**Exhibition of Project Application for Rozelle Village/Balmain Leagues Club
Development off Victoria Road, Rozelle (MP11_0015)**

Thank you for your letter dated 17 April 2012 requesting Transport for NSW (TfNSW) comments on the environmental assessment documentation for the proposed Rozelle Village development (MP11_0092).

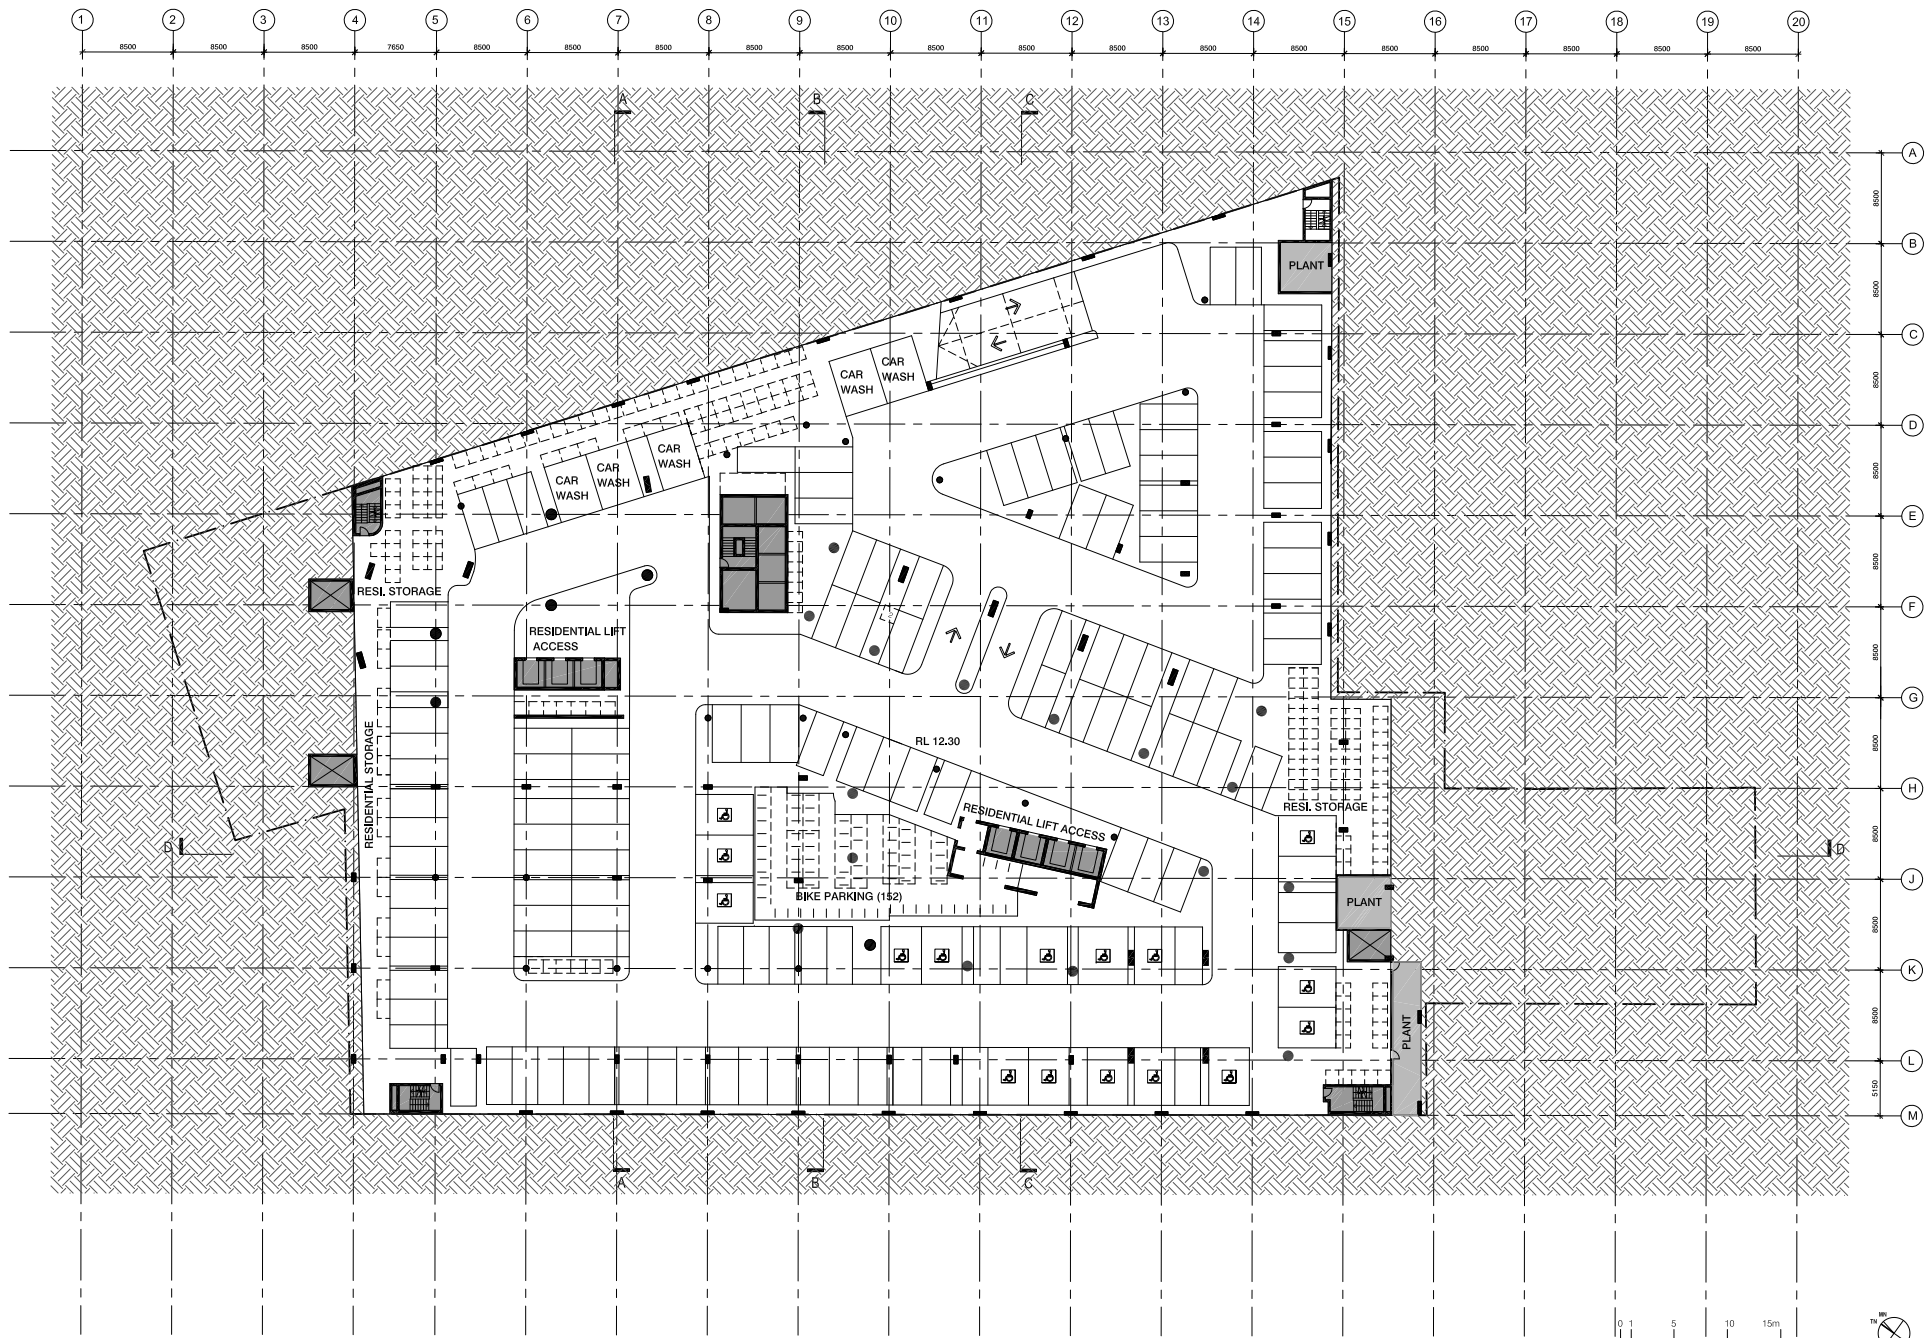
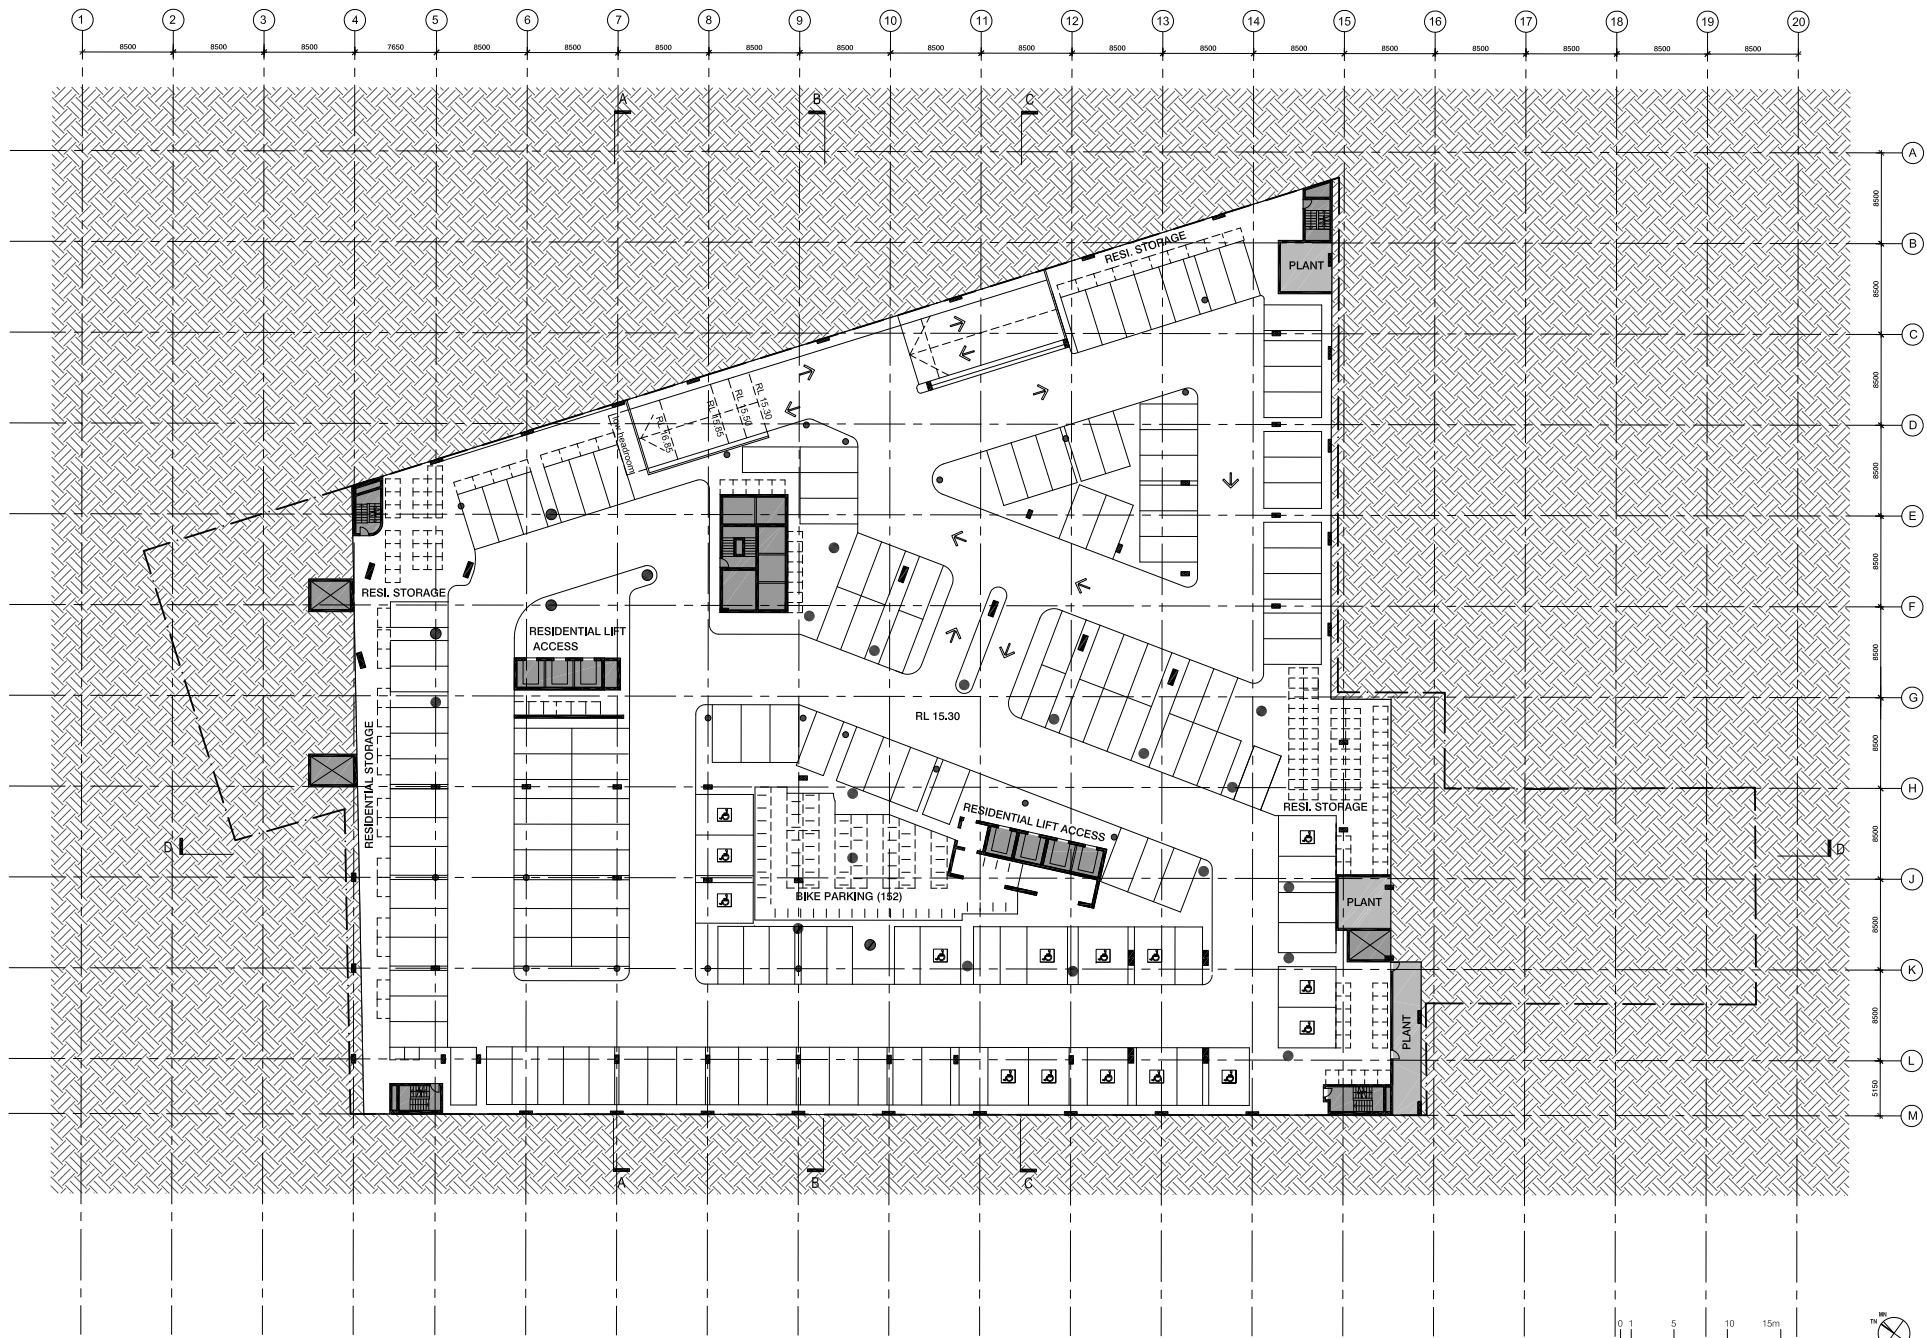
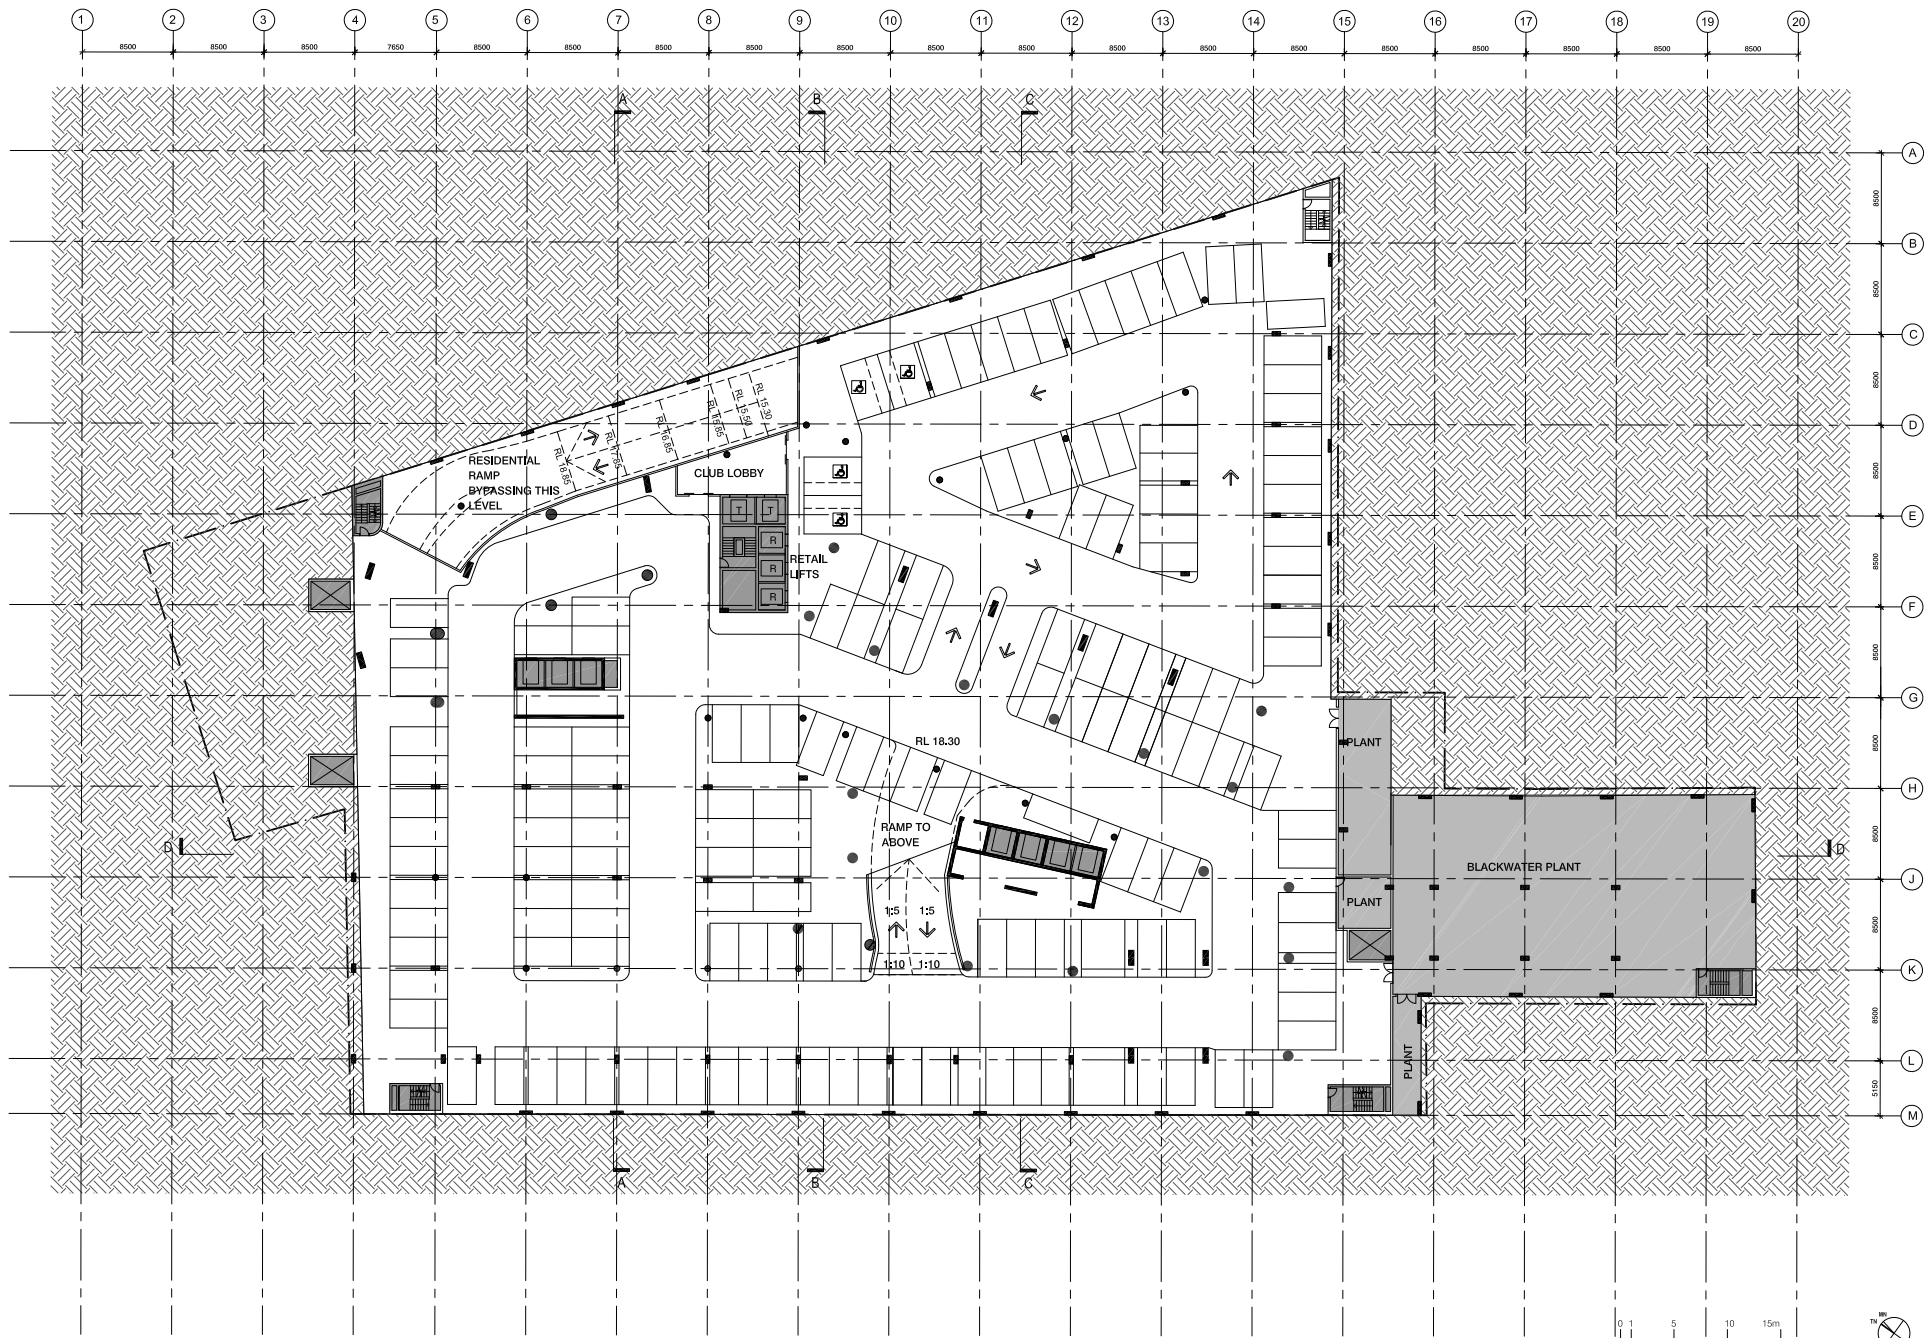
TfNSW has reviewed the relevant documentation and found that the proposed development architectural plans do not include structural details or excavation levels of its foundations. In addition, it was found that an assessment is required that indicates that the running tunnels and the proposed basement structure can co-exist.

Our review also found that the proposed development falls within the Zone of Influence of the Metro running tunnels (as defined by the *'Development Guidelines within the vicinity of Sydney Metro Network Line 1'*, document reference no.CBD-2100-PBACH-R-GN-0159). Encroachment of the proposed building basement excavation within the Zone of

Influence is expected to be of a high risk to the potential future Rozelle metro station cavern as a consequence of interpreted geological conditions and vertical separation between the cavern and the extent of the basement. However, without details of the proposed foundations arrangement and loadings of the building basement or accurate information regarding the building footprint, a definitive judgment cannot be reached. For instance, piles will not be permitted where they are required to encroach within the protection zone.

Therefore, it is requested that structural details of proposed foundations with excavation levels be provided to TfNSW for review. This information is to be provided to TfNSW prior to the Department of Planning and Infrastructure completing their assessment of the proposal, in order for TfNSW to determine whether concurrence would be issued under the Infrastructure SEPP.
